Erection of new ground floor rear extension, new dormer roof extension & minor alterations to the front facade
41 Southdean Drive Bognor Regis

I regret that I am unable to accept your documents as a formal application until the following matters have been resolved :-

Project	Beachcroft, 41 Southdean Drive, Middleton-on-sea PO22 7TB	Scale	1:50	Date	15.03.11	checked	
Drawing	Proposed Section AA	t: 020 7404 6757 f: 020 7242 3915 e: home@clarkedesai.com					clarke:desai 
Project No.	186	Drawing No.	EX_010	Revision No.	-

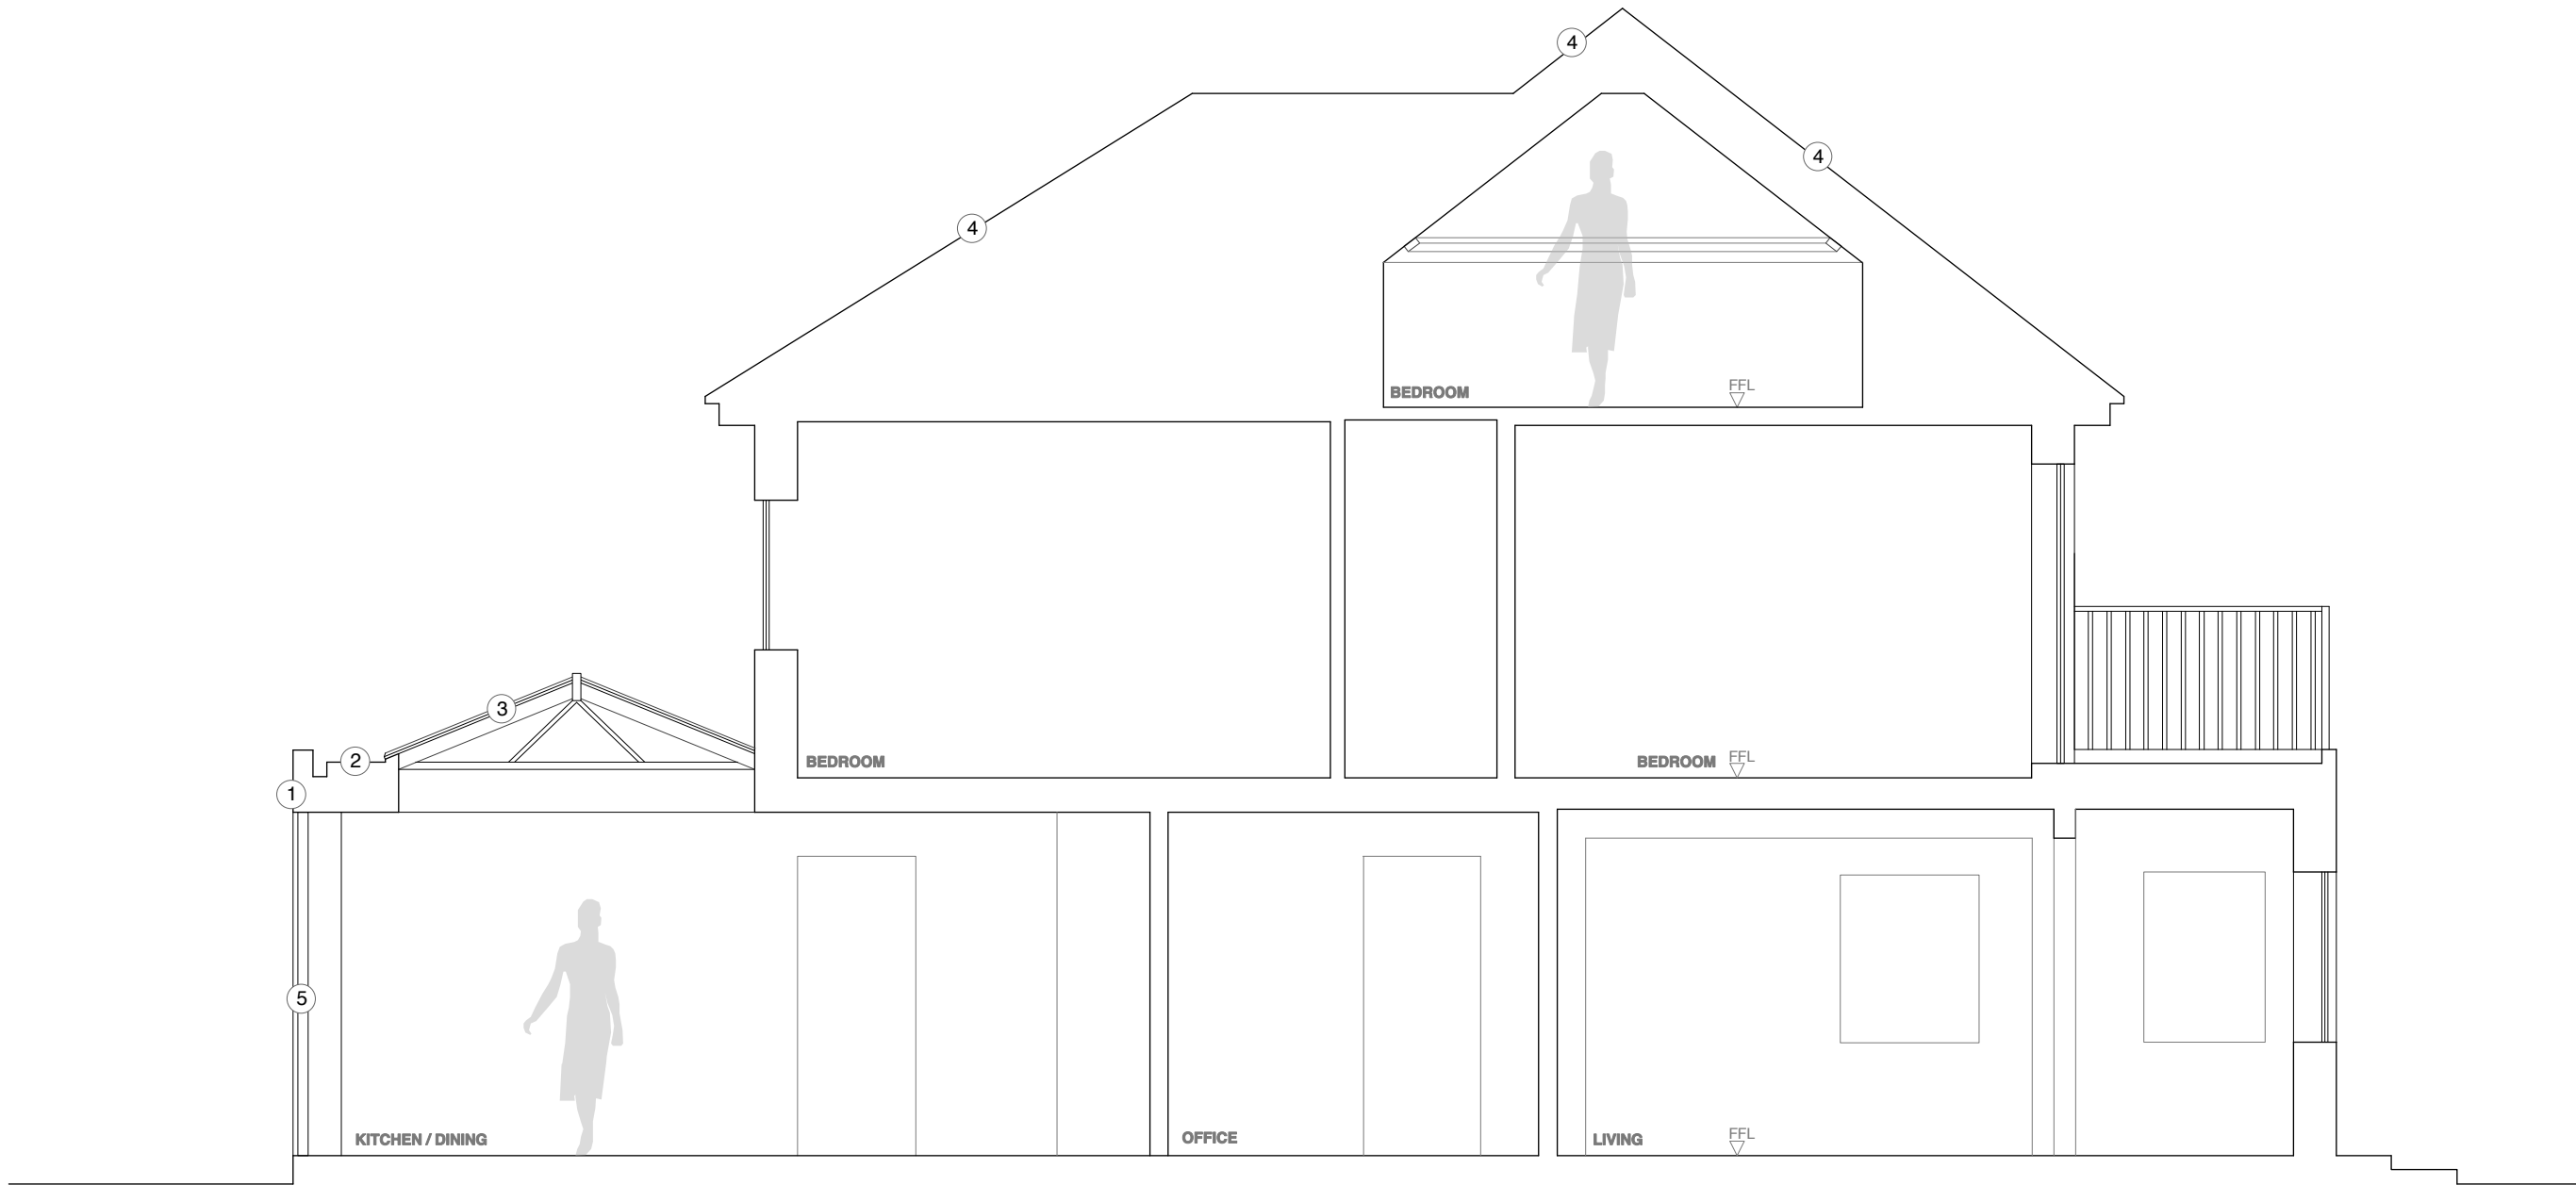
Please provide a revised plan (drawing no. EX_010) marked as existing rear elevation. This plan is currently labelled as existing section AA.
